SUSSEX ORNITHOLOGICAL SOCIETY

17 December 2021

P/155/212/RES Approval of reserved matters (layout, scale, appearance and landscaping) following outline consent P/140/16/OUT for the 'local centre' parcel which comprises of retail, community and commercial uses, 20 No residential apartments and a 70 bed care home.

The SOS **objects** to this planning application because of uncertainty about whether Southern Water can handle the increased foul water volumes that would result from this development (our concerns are detailed in "Foul Water Impacts" below), and the consequent risk of increased sewerage overflows into the Pagham Harbour SPA.

PROPOSED DRAINAGE STRATEGY

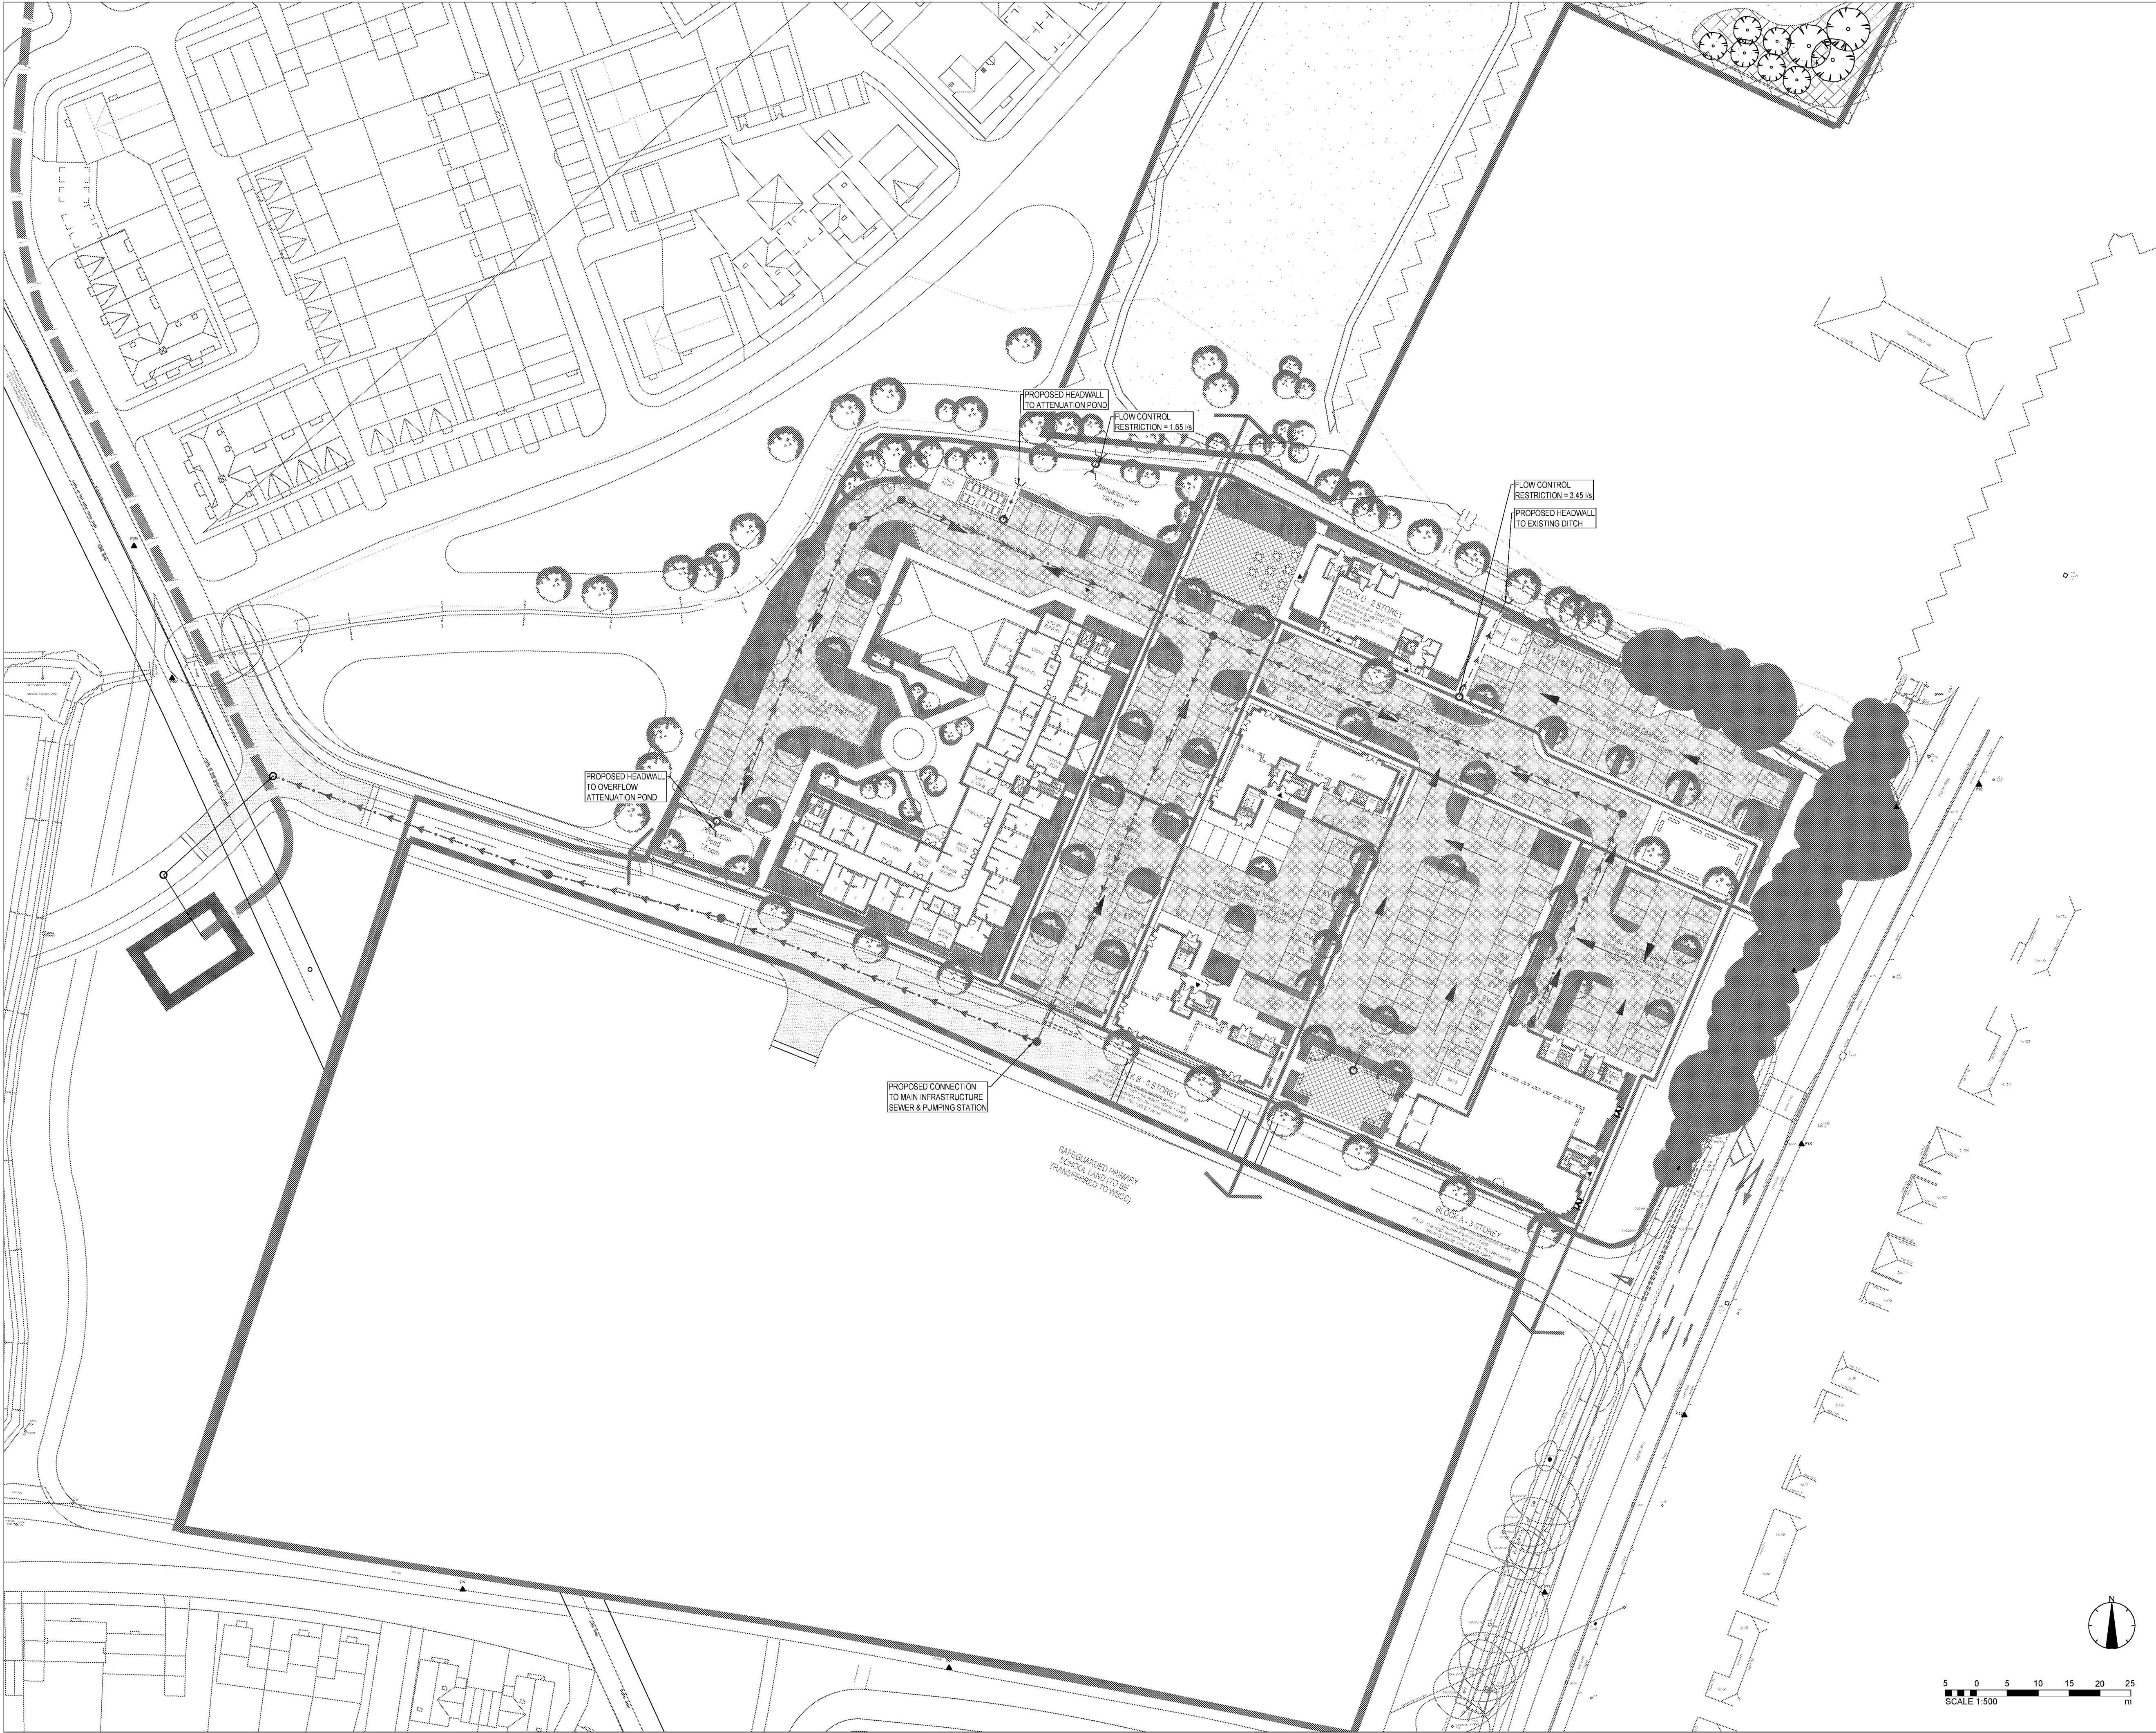
8. The Drainage Strategy Report, para 5.3 states
The Local Sewerage Undertaker is Southern Water with the nearest Treatment Works being Pagham Treatment Works. Through consultation with Southern Water, the development will be timed to align with the upgrades to the Treatment Works and the connection to the public sewer timed to align with this.

9. We understand that Pagham WTW already has high levels of sewerage discharge which overflow directly into Pagham Hbr SPA. We are not aware that there is a definite plan to upgrade this WTW, and if there is what the timing of this upgrade would be.

10. If it were proposed that foul water is to flow to this WTW we would be very concerned as to the impact of increased levels of sewerage discharges into the SPA were it not substantially upgraded. It should be noted that NE have recently assessed that Chichester Harbour SSSI – and SPA – is in “unsatisfactory, declining” condition in part because of the impact of frequent sewerage overspills into that SPA. The Pagham Hbr SPA could be facing

similar problems if steps are not taken to ensure that new developments will not exacerbate the current Pagham WTW overflows.

11. Therefore, we would ask that a condition of planning approval being given to P/155/21/RES is "That development shall not commence until Pagham WTW has been upgraded, or foul water is permanently sent to another WTW that does not overflow into the Pagham Hbr SPA."
